20110406.1/2202A/R0/TA

Graythwaite Rehab Centre Ryde Hosp - Response to Acoustic Queries

This letter presents a response to the queries raised by Renzo Tonin in their peer review of the Graythwaite Rehabilitation Part 3A acoustic report. We note that additional information in the form of an acoustic specification and generator assessment has been provided since the preparation of the Part 3A acoustic report.

Site Plan
1:500 @A1
20.05.11
3717-DA-001
50m

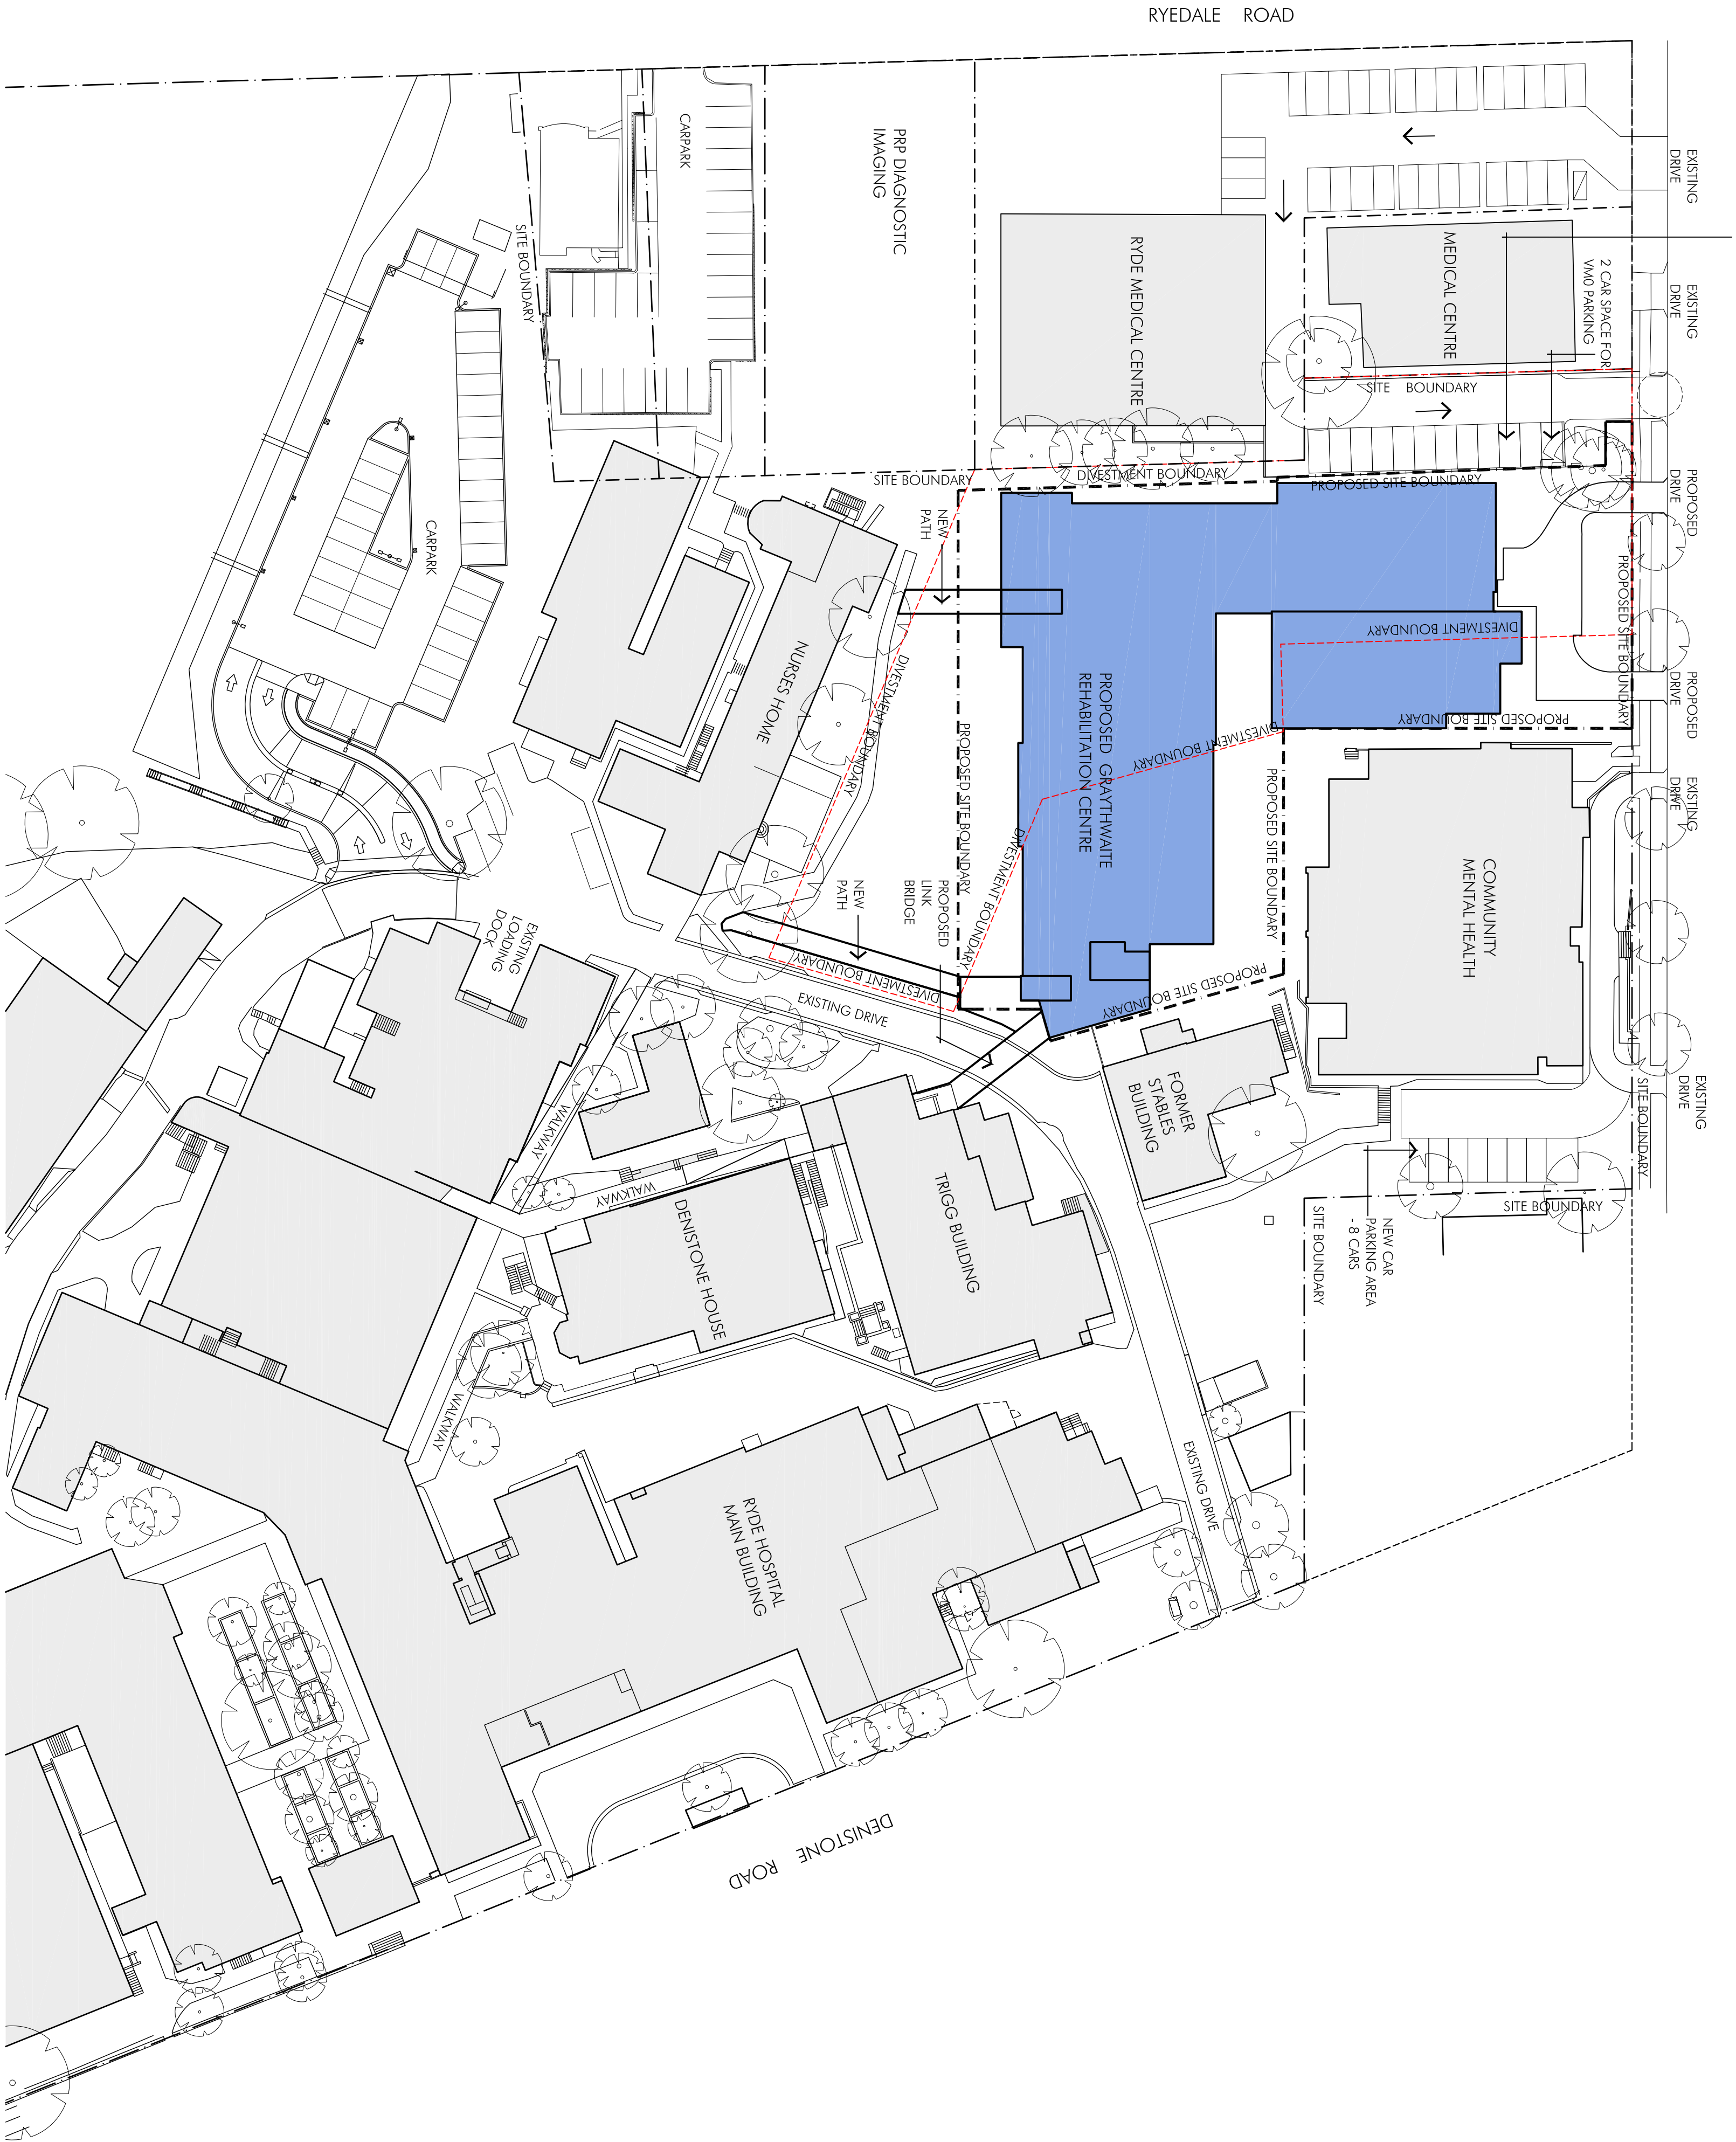
- The site map indicates Stage One of the development; it was requested that additional stages be removed for clarity. The full site map as presented in earlier revisions of the report is presented below.
